Please find attached information revised to ADC's 1No comment below.

Engineers Comments Regarding Surface Water Drainage

Condition 10

BEDDING DETAILS LANDSCAPE AREAS

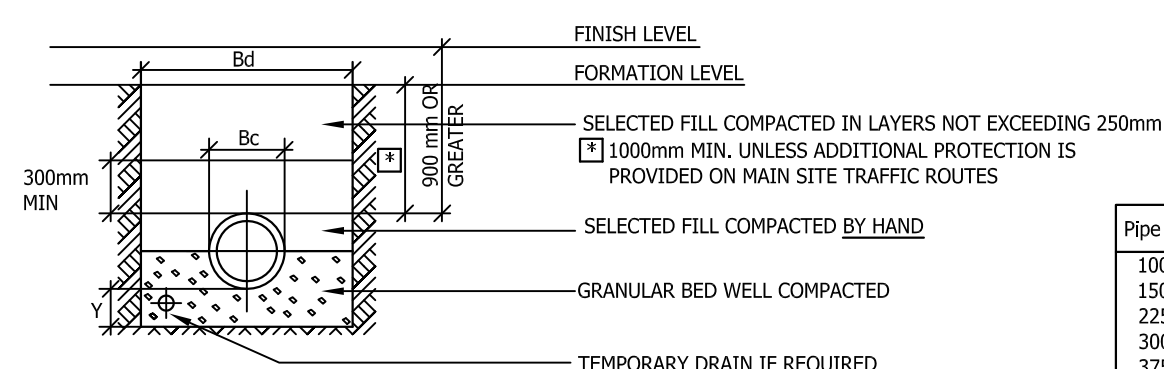
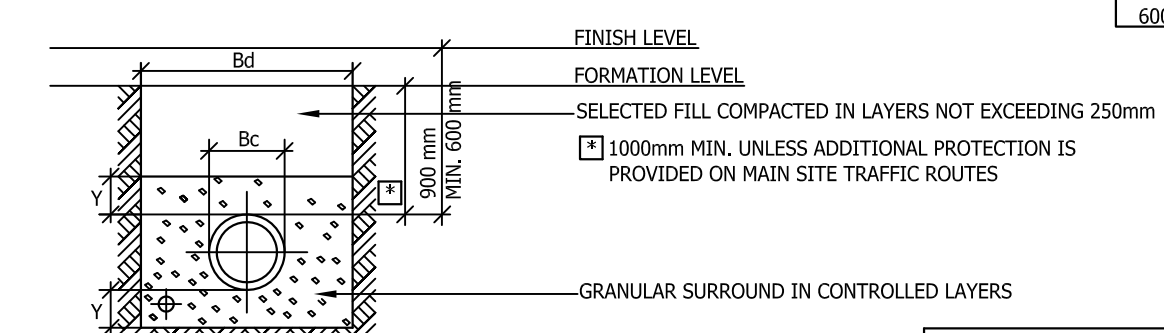
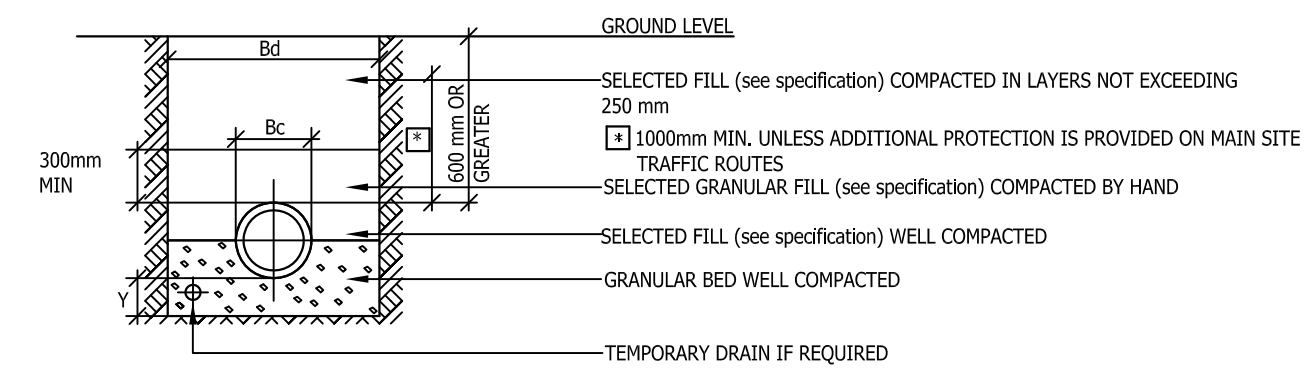
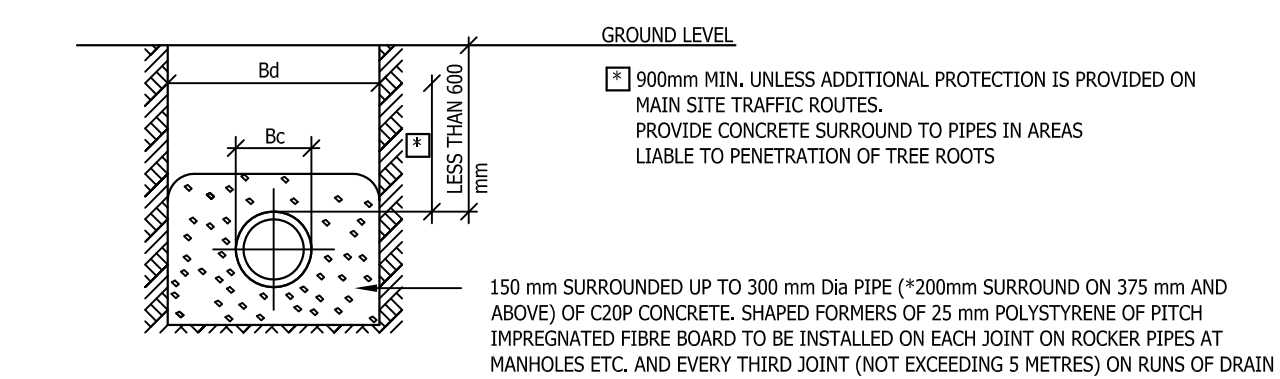
1. The trial pit TP01 is undersized (0.3m x 0.3m rather than 0.3m x 1m specified by BRE365). Please apply a safety factor of 3 to the calculations. Three tests were completed, the date of testing is assumed to be 24/01/2018 (from the test pit stratum record) however this is not clear. Please clarify. Done. Date confirmed and factor of safety has been applied.
2. Construction detail drawings need to be included for:
 - a. Inspection chambers Done, but requires a concrete collar and a granular surround.
 - b. Channel drains Done
 - c. Pipe bed and surround Done

450mm INSPECTION CHAMBER

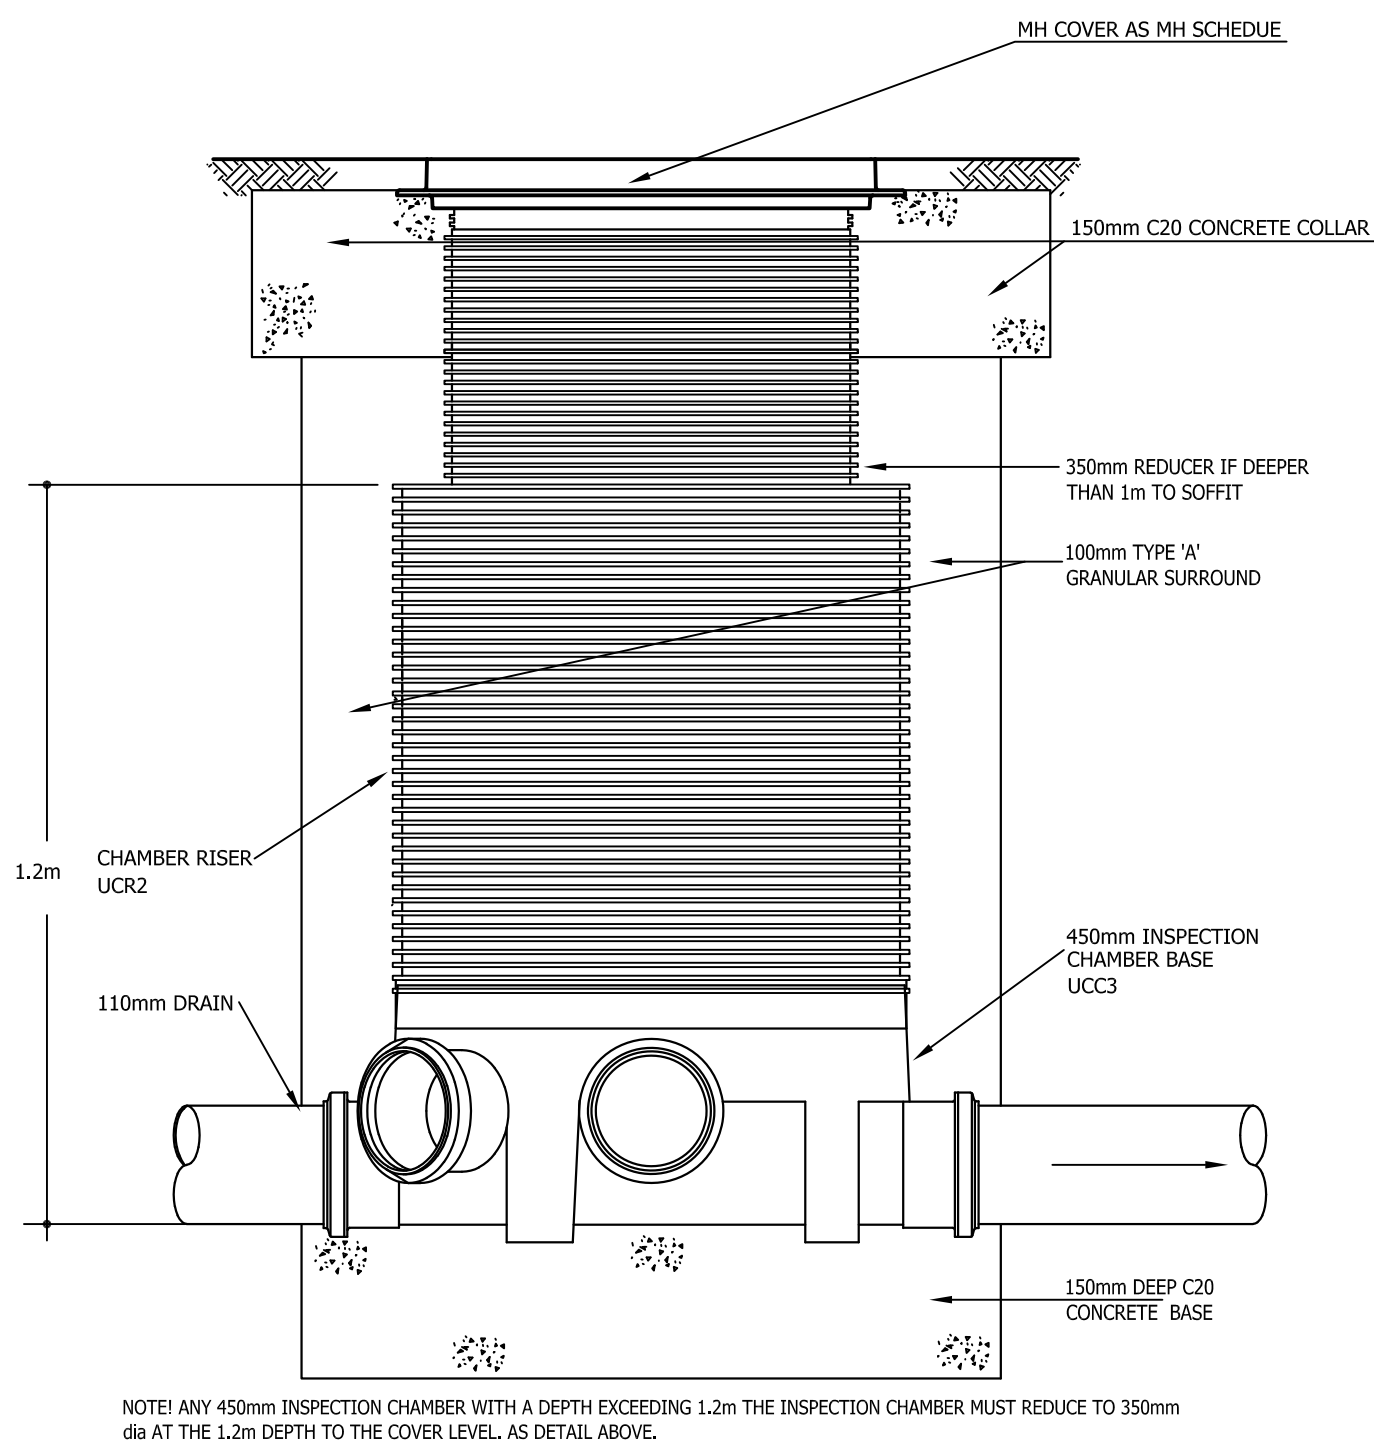
Updated plans/construction details (to discharge condition 10) will need to be included. Plan included, if possible please also add the construction details once the inspection chamber has been amended.

I don't know why they prefer granular to concrete surround for inspection chambers – seemed simpler just to change the detail rather than question this.
